From: Paul Cann <Paul.Cann@arun.gov.uk>
Sent: 27 September 2021 13:56
To: Planning.Responses <Planning.Responses@arun.gov.uk>
Cc: Arjan De Jong <Arjan.DeJong@arun.gov.uk>
Subject: RE: Planning Consultation on: AB/113/21/DOC

Engineers comments in respect to surface water drainage;

Application No:	AB/113/21/DOC
Registered:	26th August 2021
Site Address:	30 Ellis Close Arundel BN18 9LG
Description of Works:	Approval of details reserved by condition imposed under AB/39/18/PL relating to conditions 3-Construction Management Plan, 4-surface water drainage & 5-foul & surface water sewerage disposal.

Drawing Title **Topographical Survey, Proposed Levels & Drainage GA**

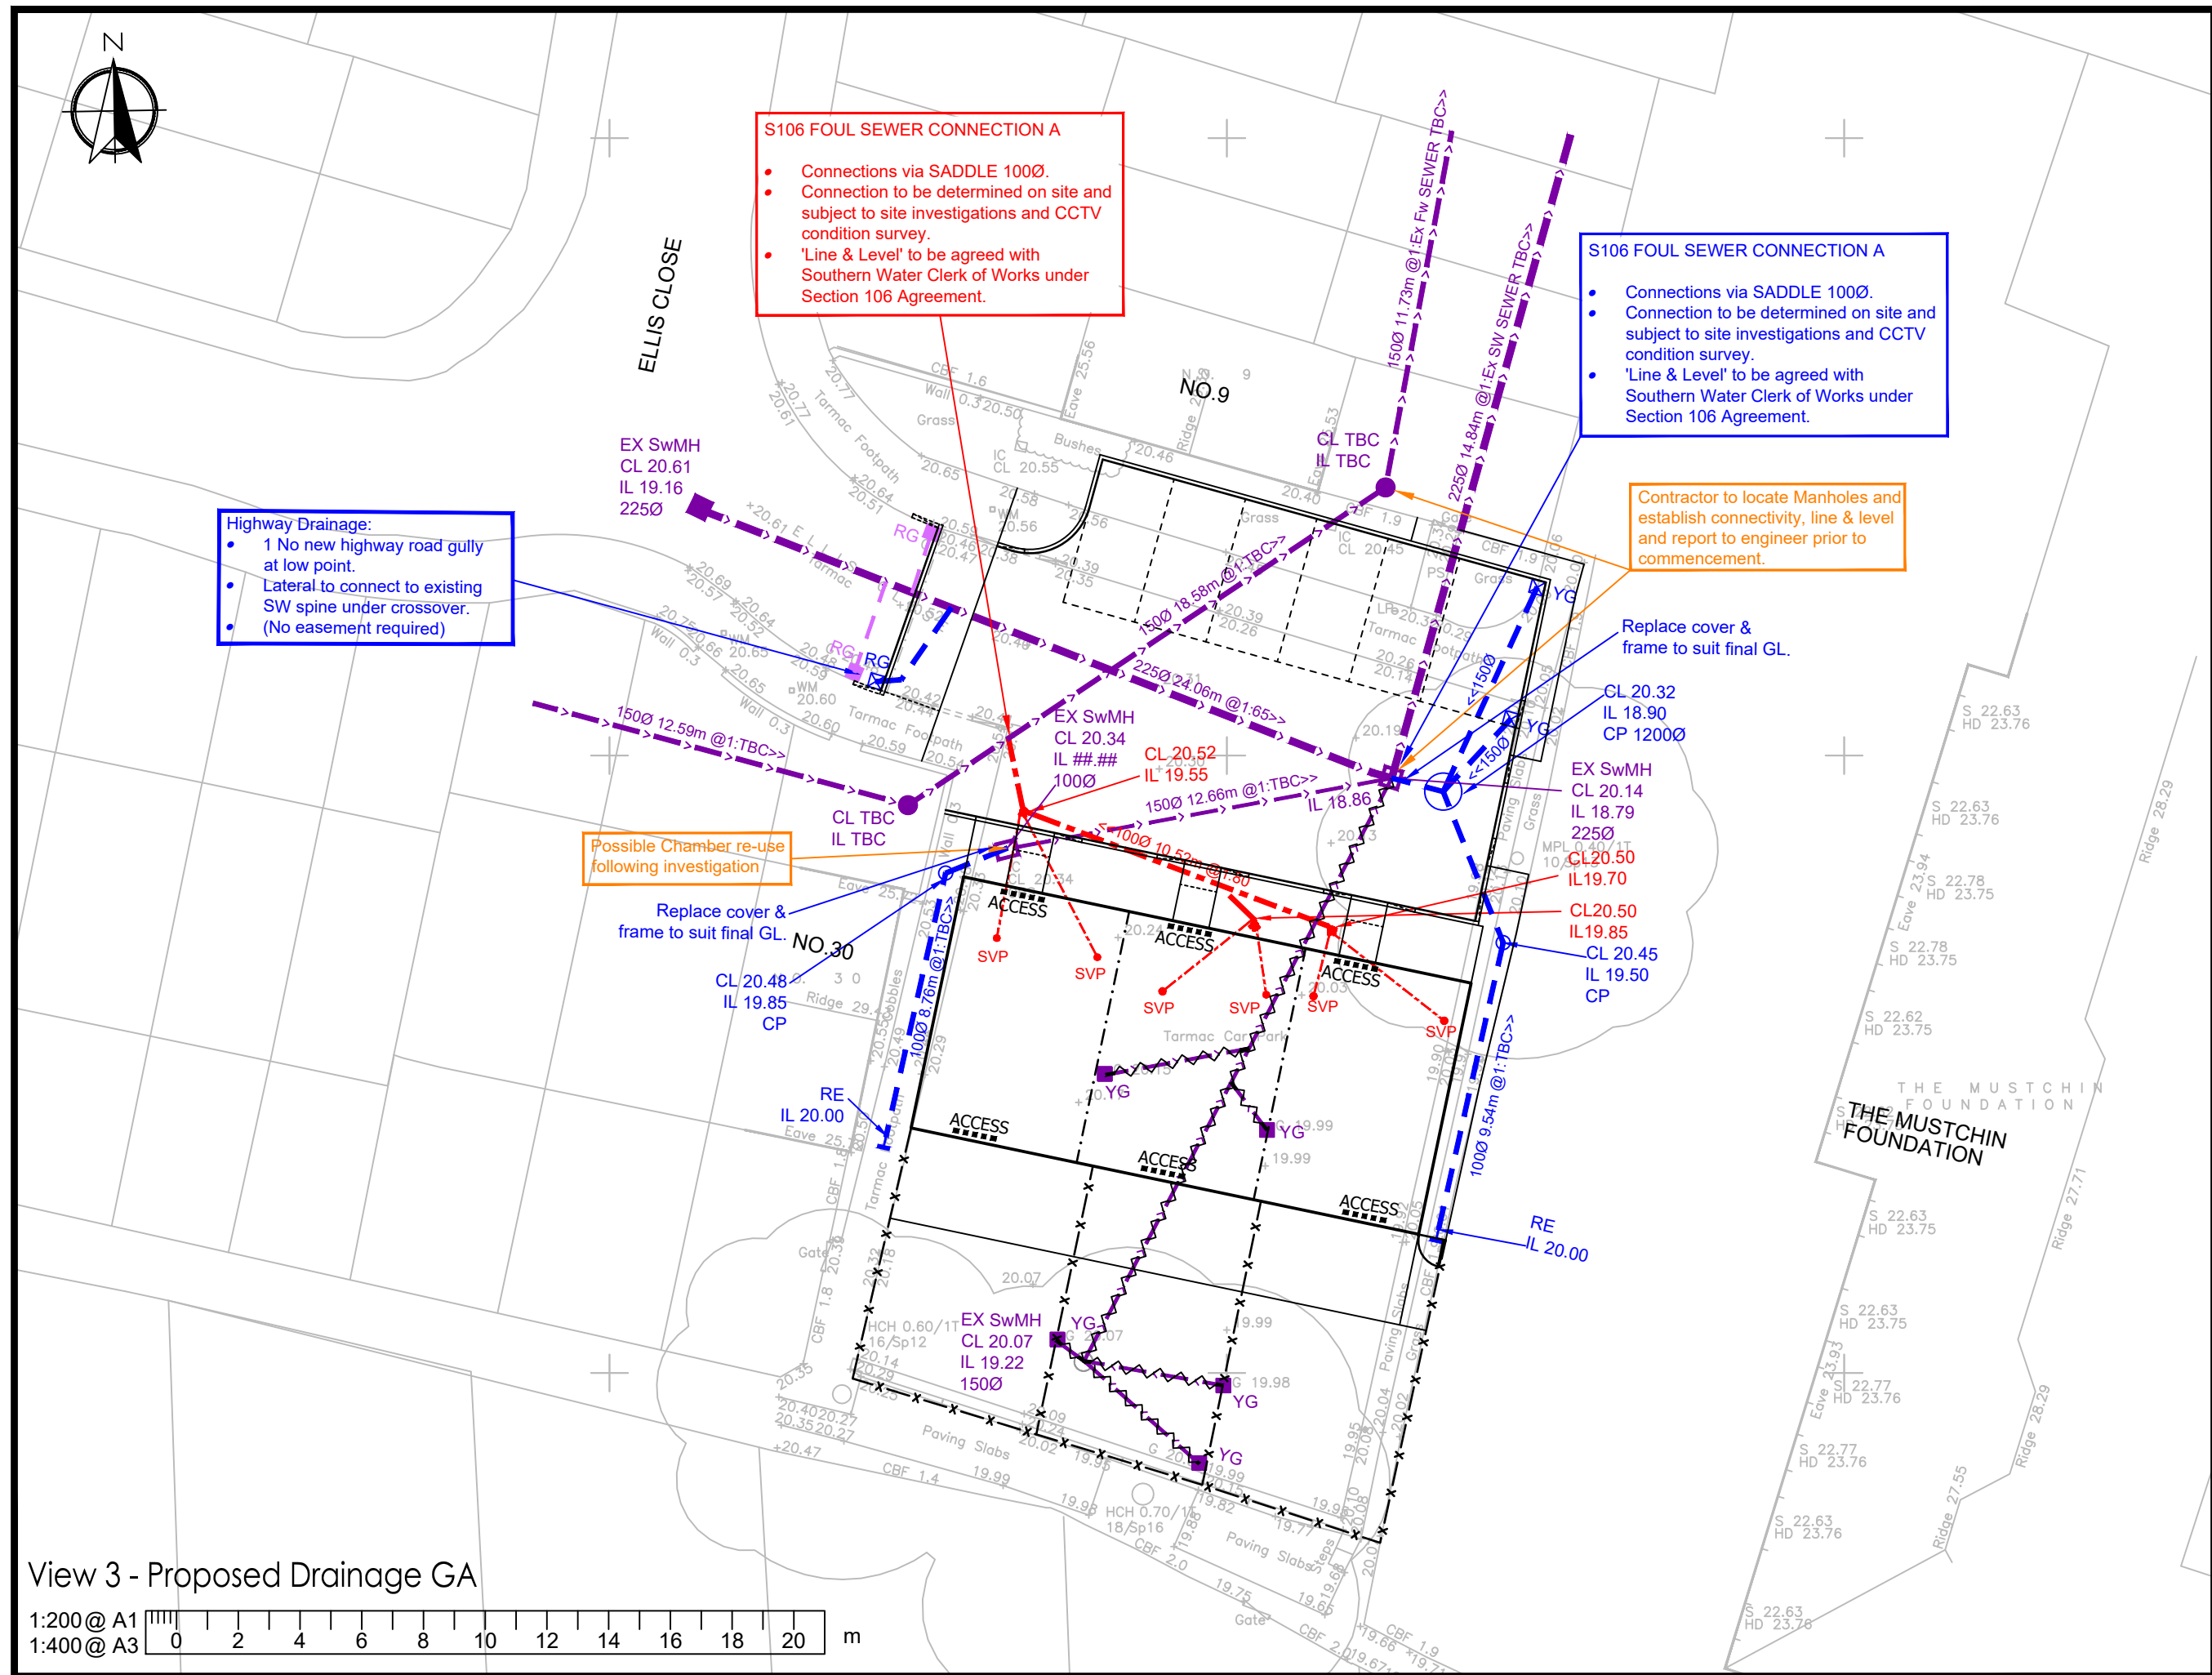
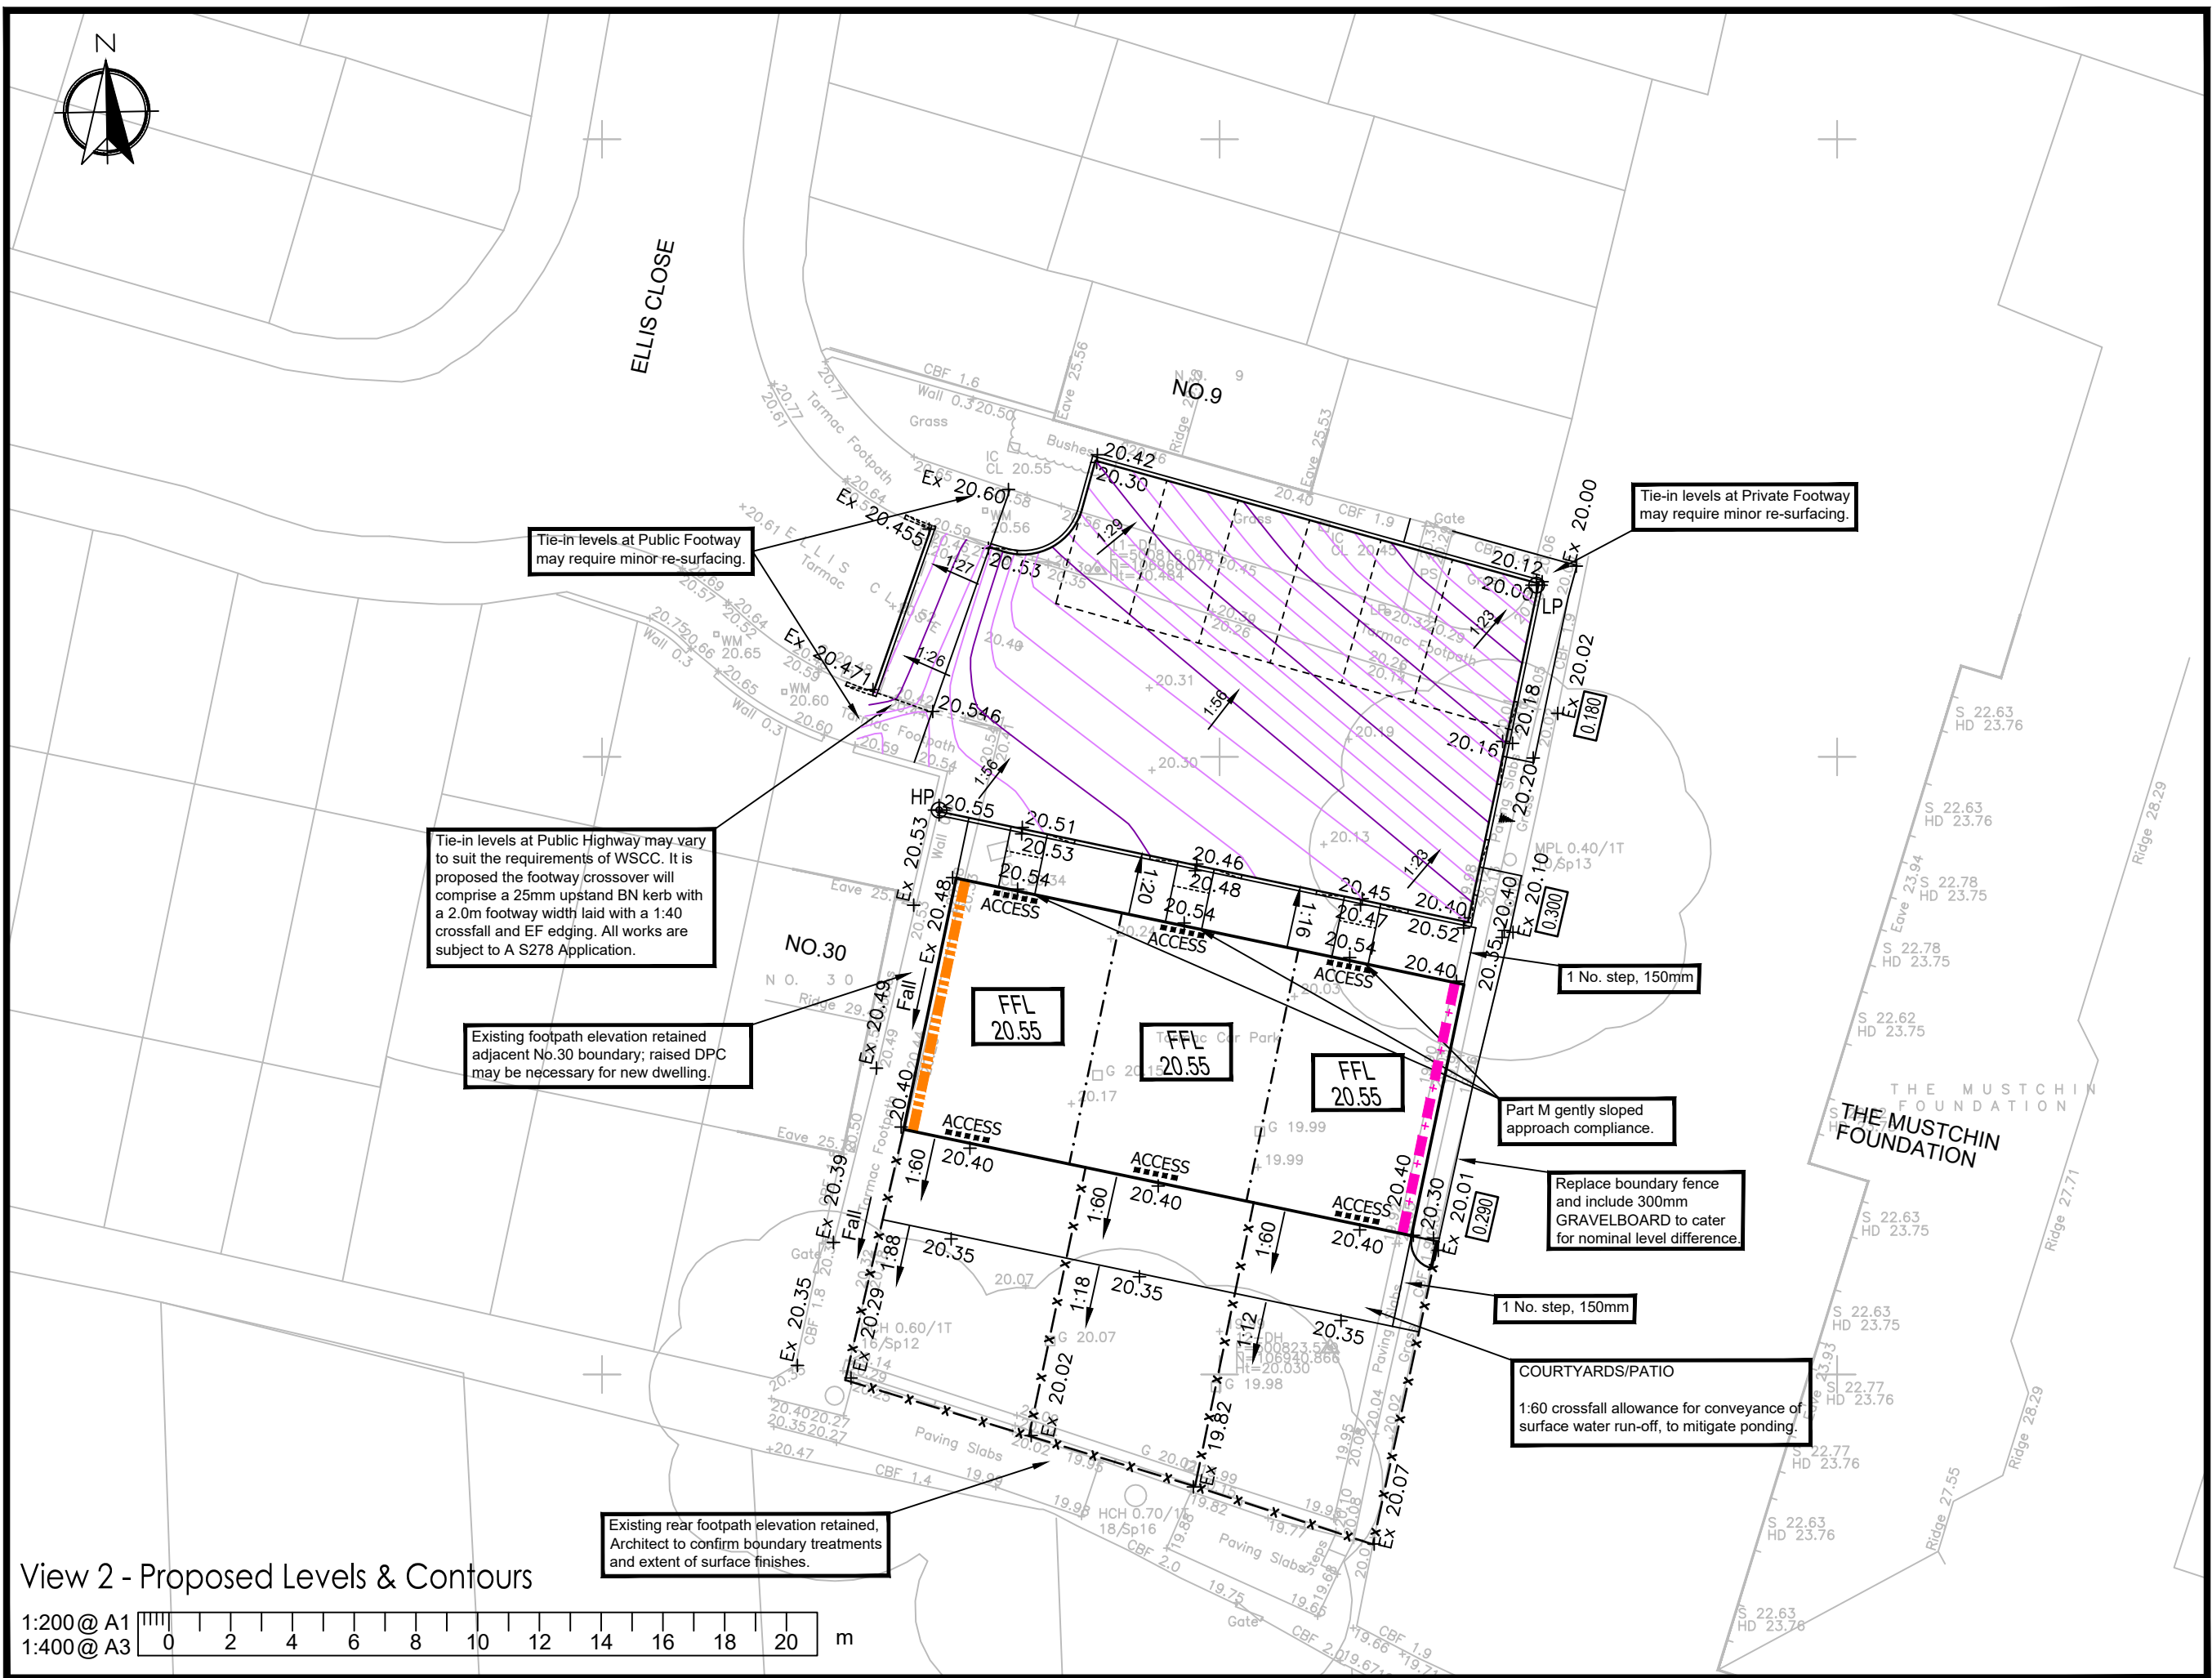
1. On the assumption that the surface water sewer being connected to is deemed vested under 2011 legislation, please provide evidence of Southern Water's approvals to the connections.
2. New highway gully to be connected via oblique junction – add note.
3. Connections to be made to existing manholes (2no.) to be made at soffit to soffit level – indicate level and connecting pipe diameter.
4. Upgrade yard gullies to road gullies to provide increased resilience.
5. Where existing surface water drain is to be grubbed up – add note that manhole is to be made good inside.
6. Proposed manhole cover replacements (2no.) to be ductile iron. Please also specify loading grade.
7. Show rainwater pipes including points of connection. Connections to be made to manholes where possible or via oblique junctions.

8. Note referring to the proposed connection to the existing manhole in the car park area refers to a saddle connection and 'foul'. Please adjust note.
9. 1200mm catchpit construction detail – specify ductile iron cover/frame & polypropylene coated step rungs/irons.
